From: Breezie Allwright <Breezie.Allwright@arun.gov.uk>
Sent: 12 January 2026 08:26
To: Planning.Responses <Planning.Responses@arun.gov.uk>
Subject: Fw: R/215/25/HH

From: [REDACTED]
Sent: 28 December 2025 11:37
To: Breezie Allwright <Breezie.Allwright@arun.gov.uk>
Subject: Re: R/215/25/HH

DO NOT AGREE TO PLANNING KITCHEN AS SO CLOSE TO MY HOME
CREATES AN ALLEY TUNNEL, GAP ,OF ONLY 1 METER, WIDE PLANNED KITCHEN EXTENSION SEE
PLAN DIRECTLY CLOSE OVERBEARING IMPACT OVER SHADOWS MAIN HABITABLE ROOM AND
CONSERVATORY

Drawing:  
**Plans and elevations as proposed**

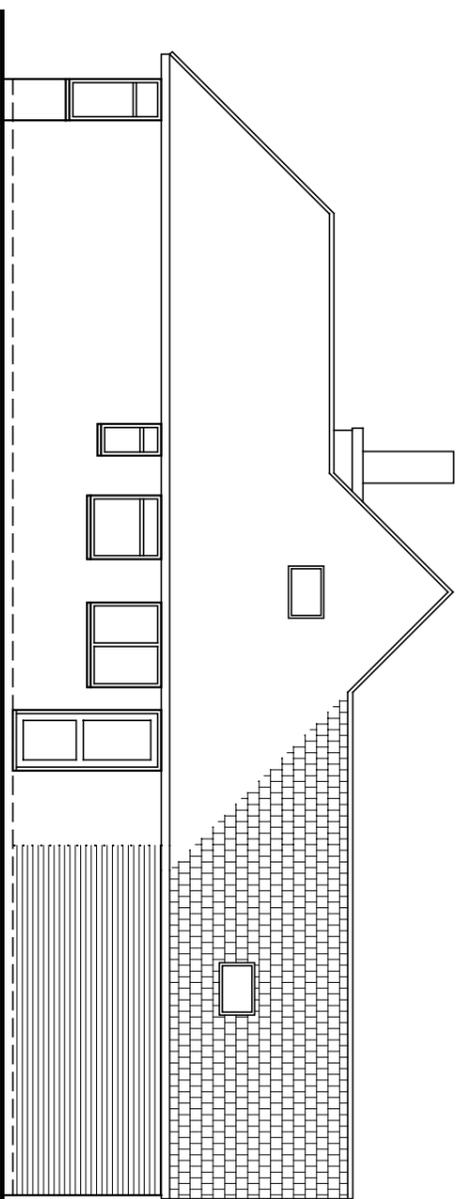
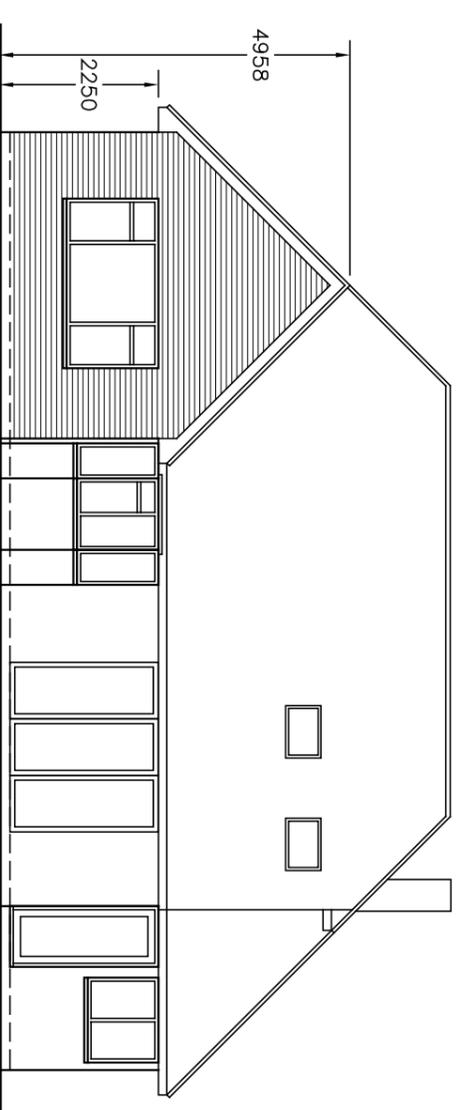
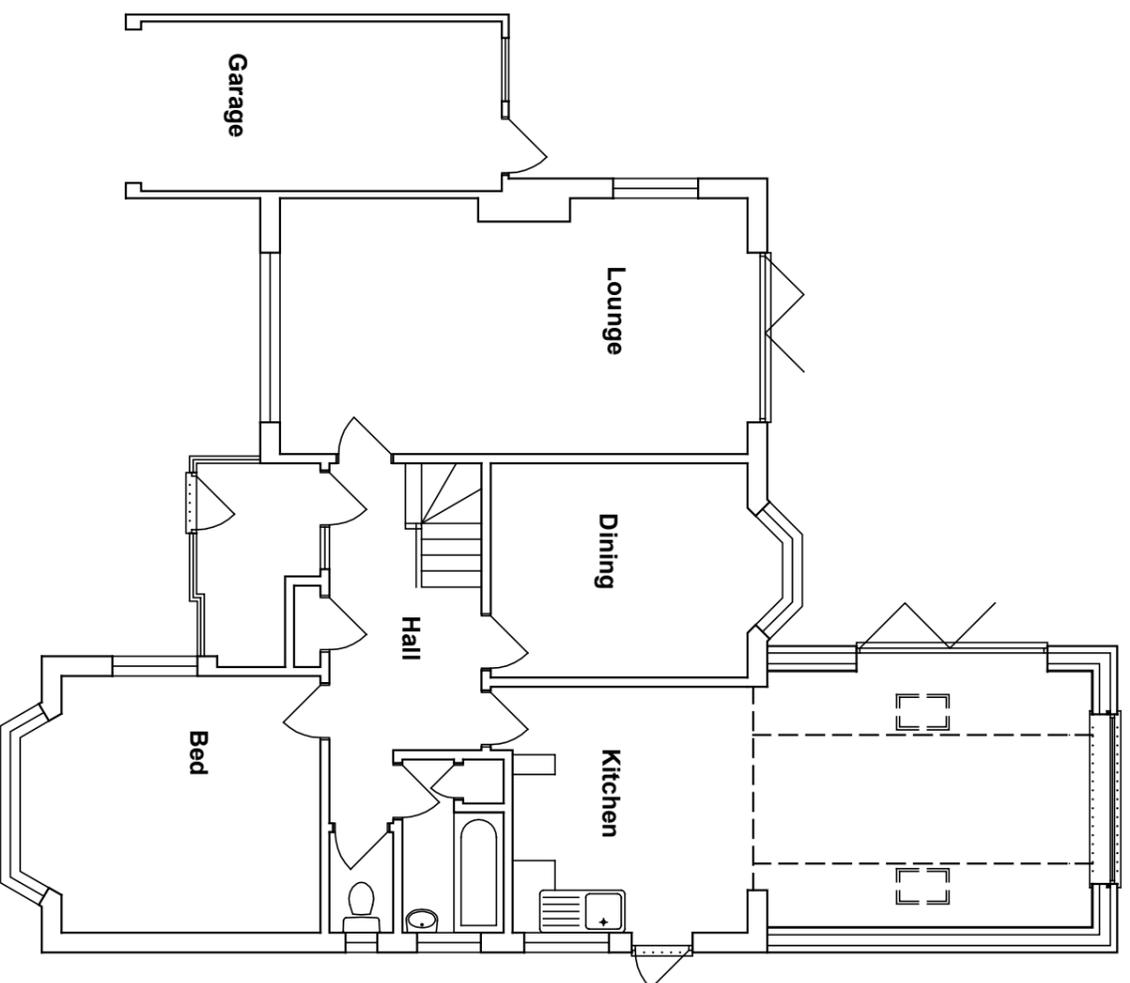
Proposed plans will leave "21 ft of brick wall and gutter " , running along my south border view, in my direct view from my home,

my south border outlook would be unsightly over shadowing overbearing ,intrusive unsightly

PLEASE MENTION MY TOTAL OPPOSITION ALSO TO HEIGHT

21 ft of wall on south facing border i fear will

- Overlooking and overshadowing
- Daylight and sunlight to habitable rooms

planned extension will block sunlight to main living are and also conservatory,

my south border where light comes from is where thompsons plan to build ,wall and gutter will be high enough to make this occur
